PLANNING AMENDMENT

THE PLOUGH SITE, ROMAN BANK, LONG SUTTON

ERECTION OF DWELLING ON
PLOT 1 WITH ROADS + SEWER
INFRASTRUCTURE DEVELOPMENT

Amendment: Change beech hedging to laurel
Dwg. No.97/12 01E

date SEP 97	scale(s) 1 200
job no 97/12	drg no 01AB

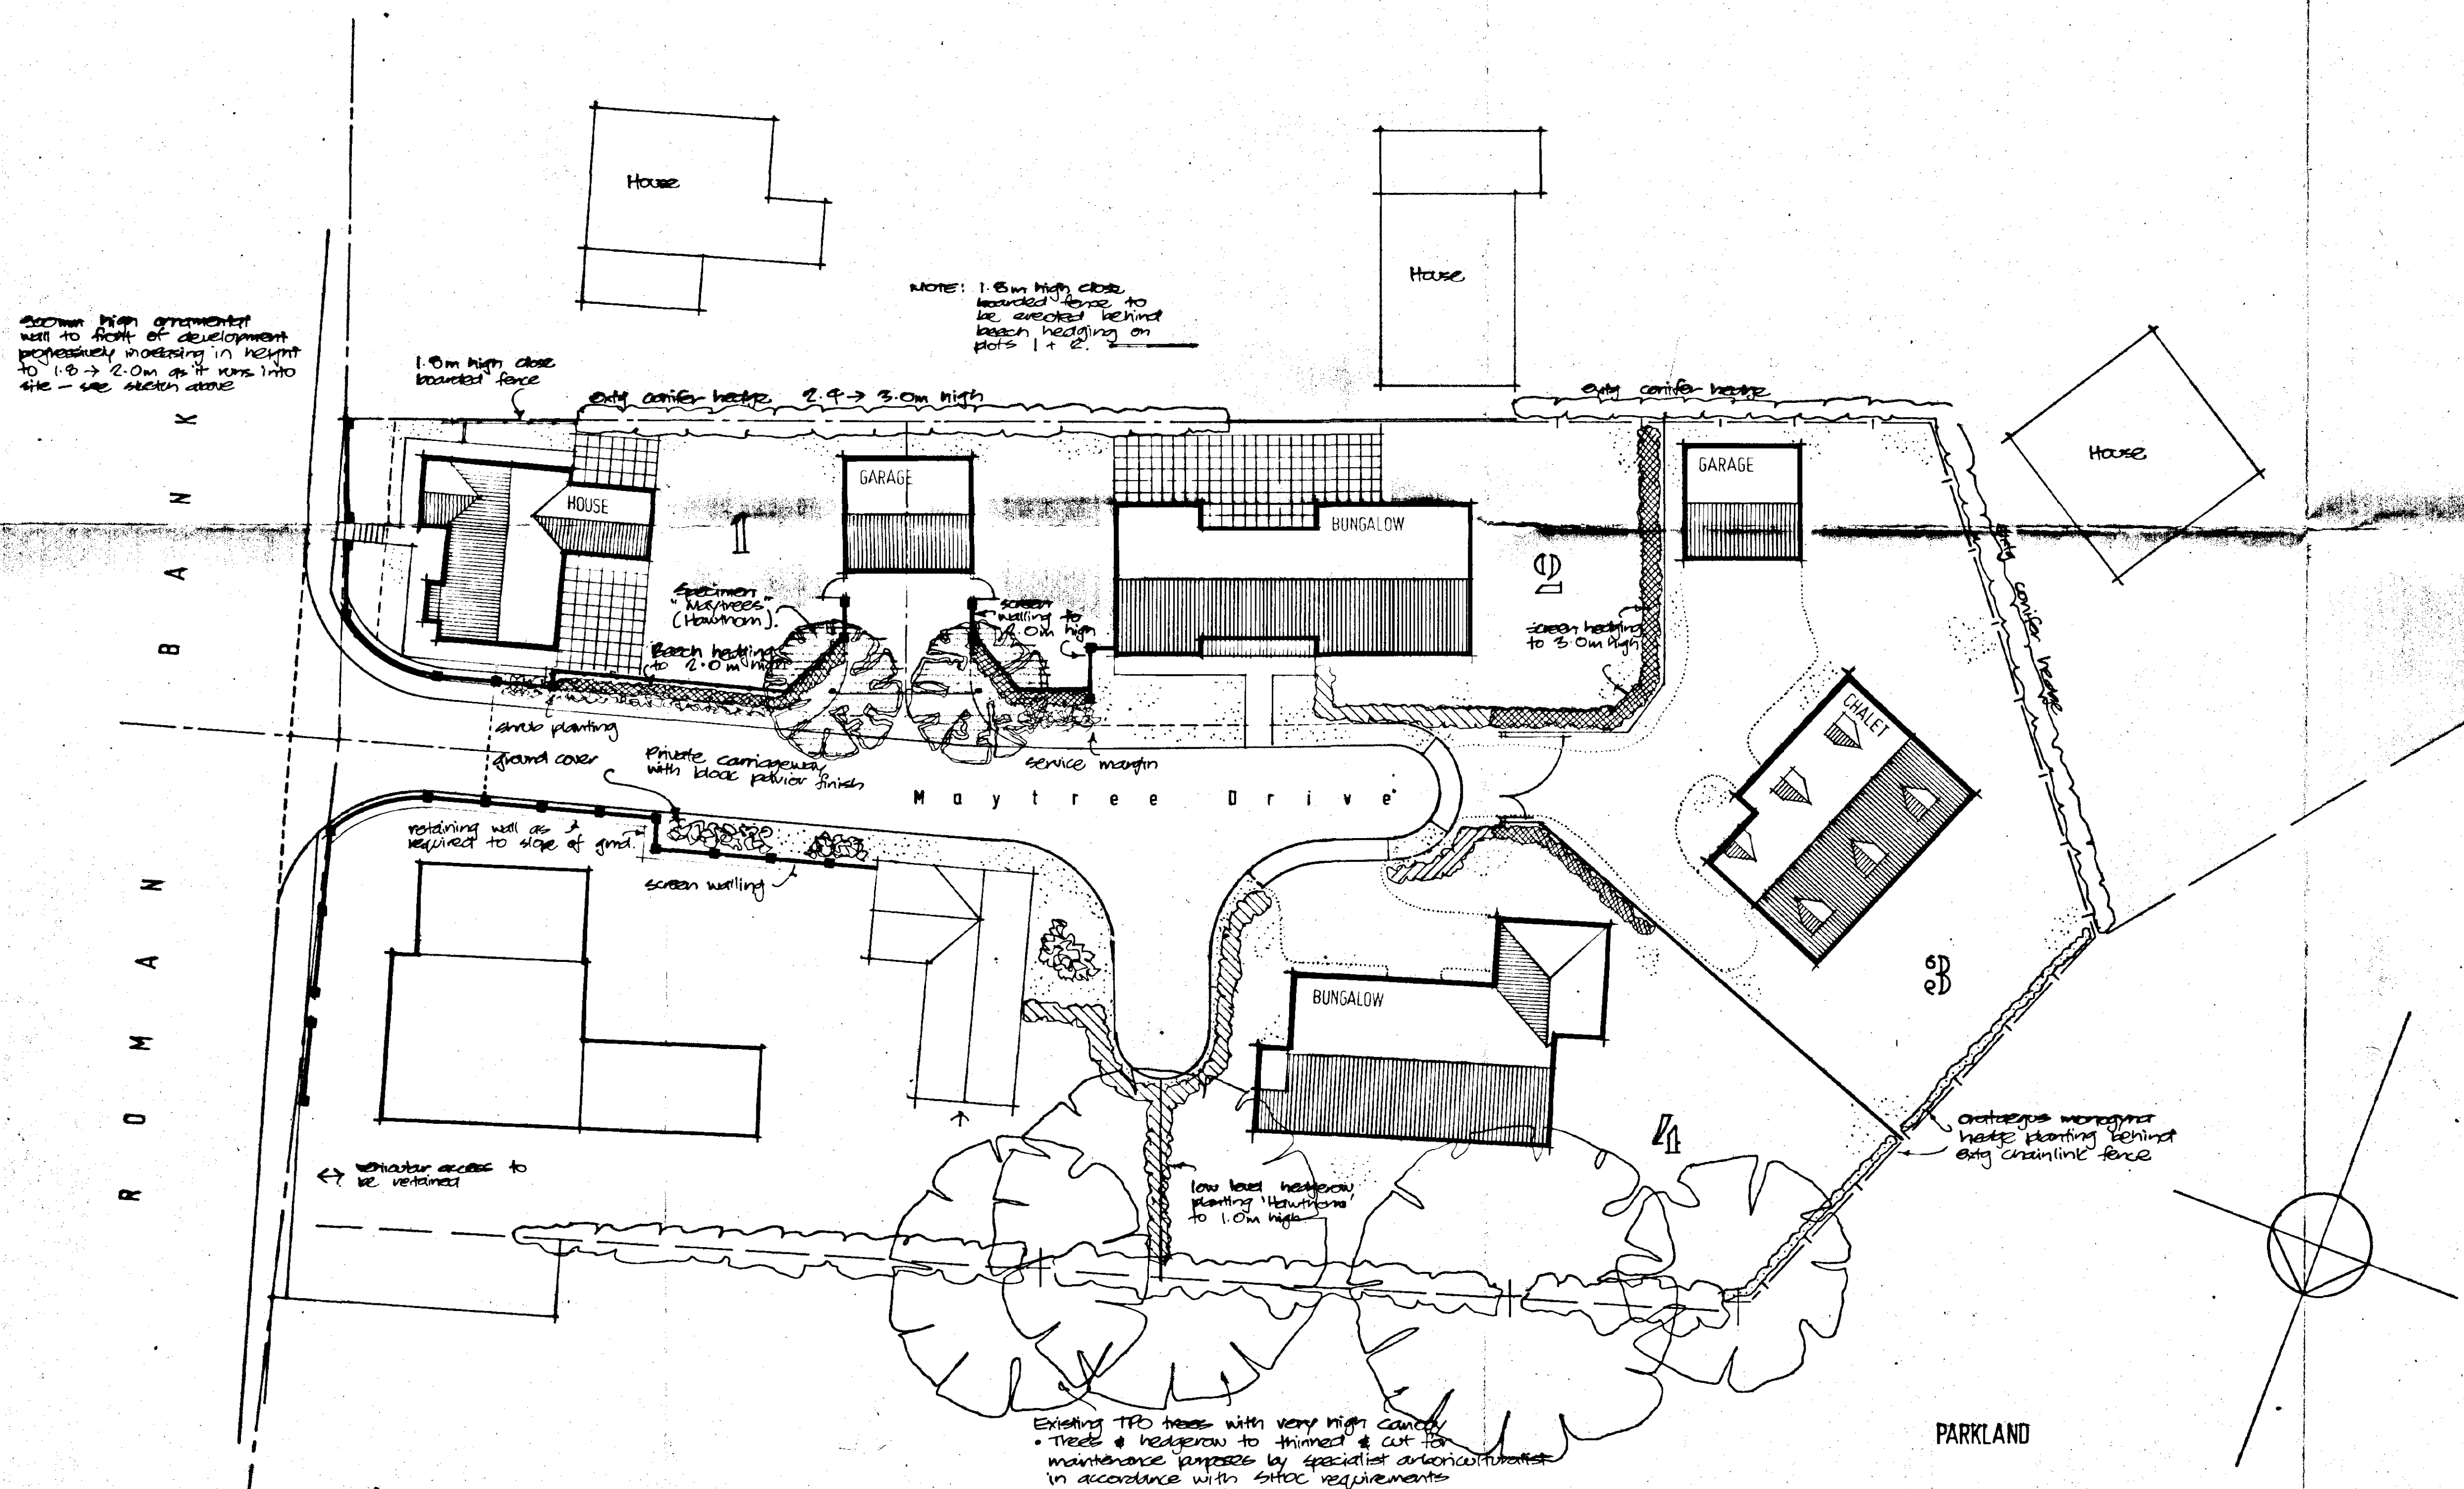
SIDE WINDOW TO DWELLING FOR
PLOT 1 + 1.8M HIGH CLOSE BOARDED
FENCE BEHIND BEECH TREES PLANTS
(1 + 2)

drg no
 01E

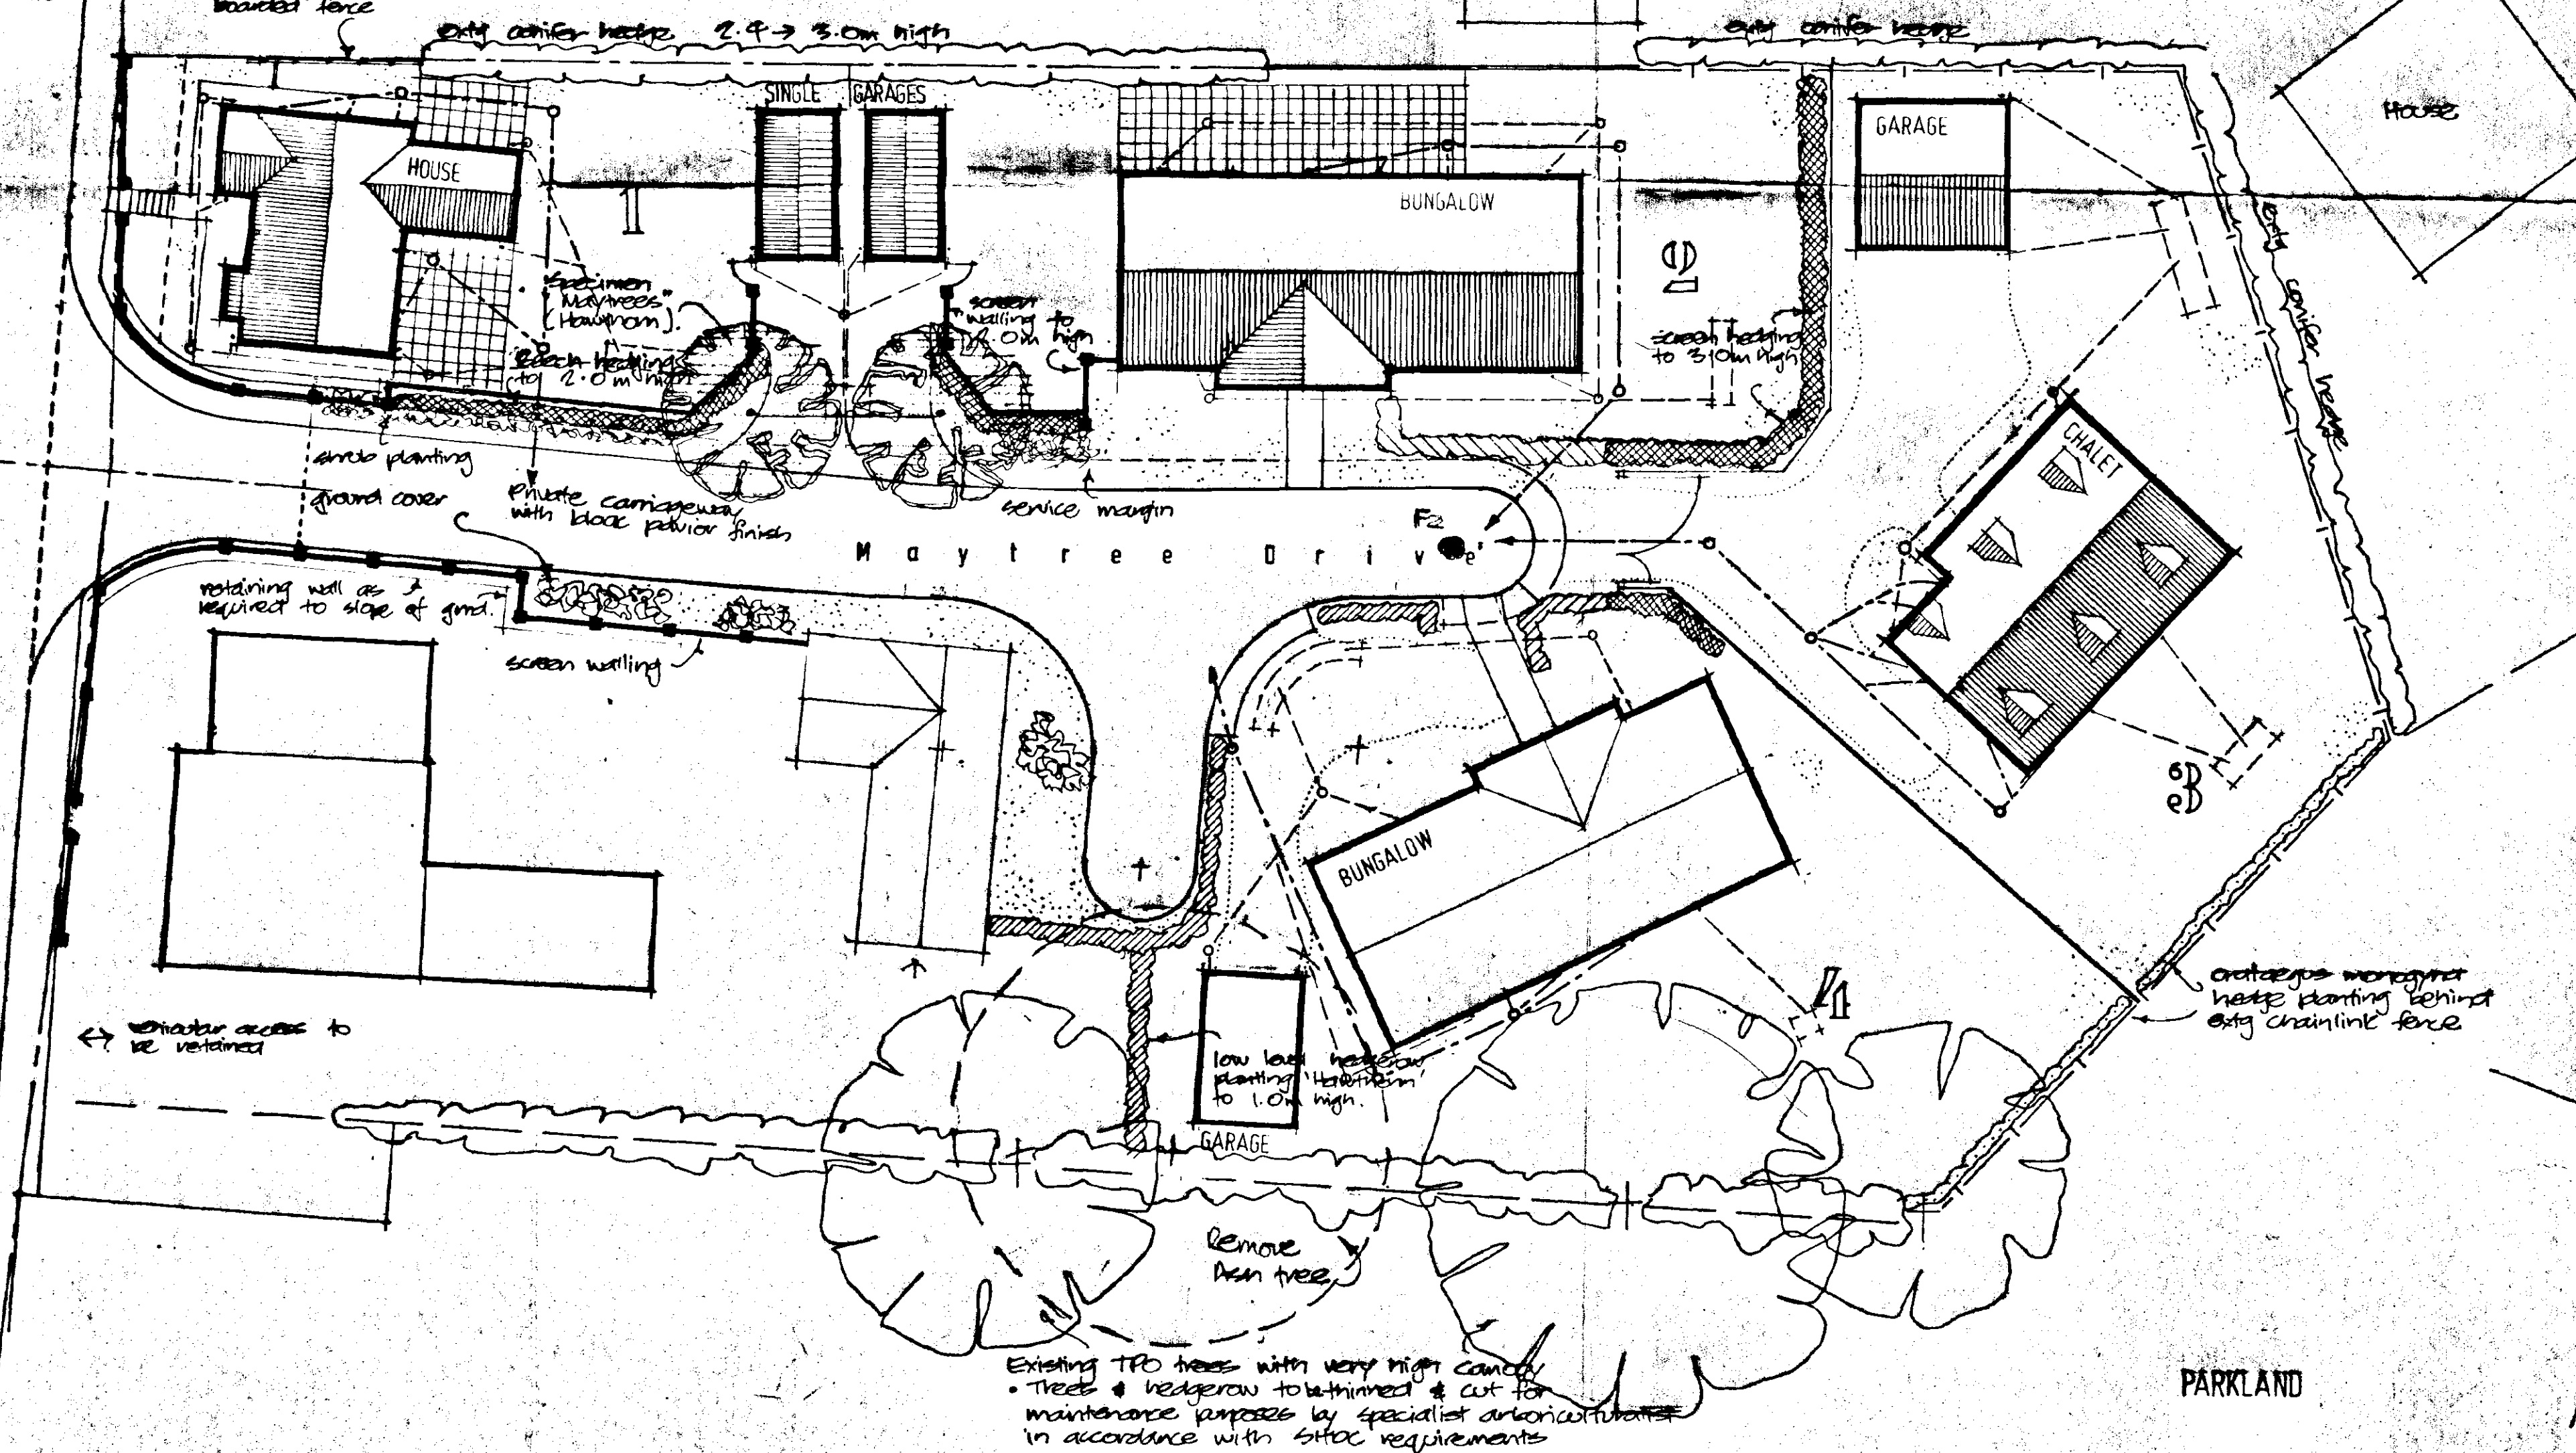
Change Beech hedge to
dandel to ensure Green All
Year round - Beech in winter will
just blend into brick wall colour
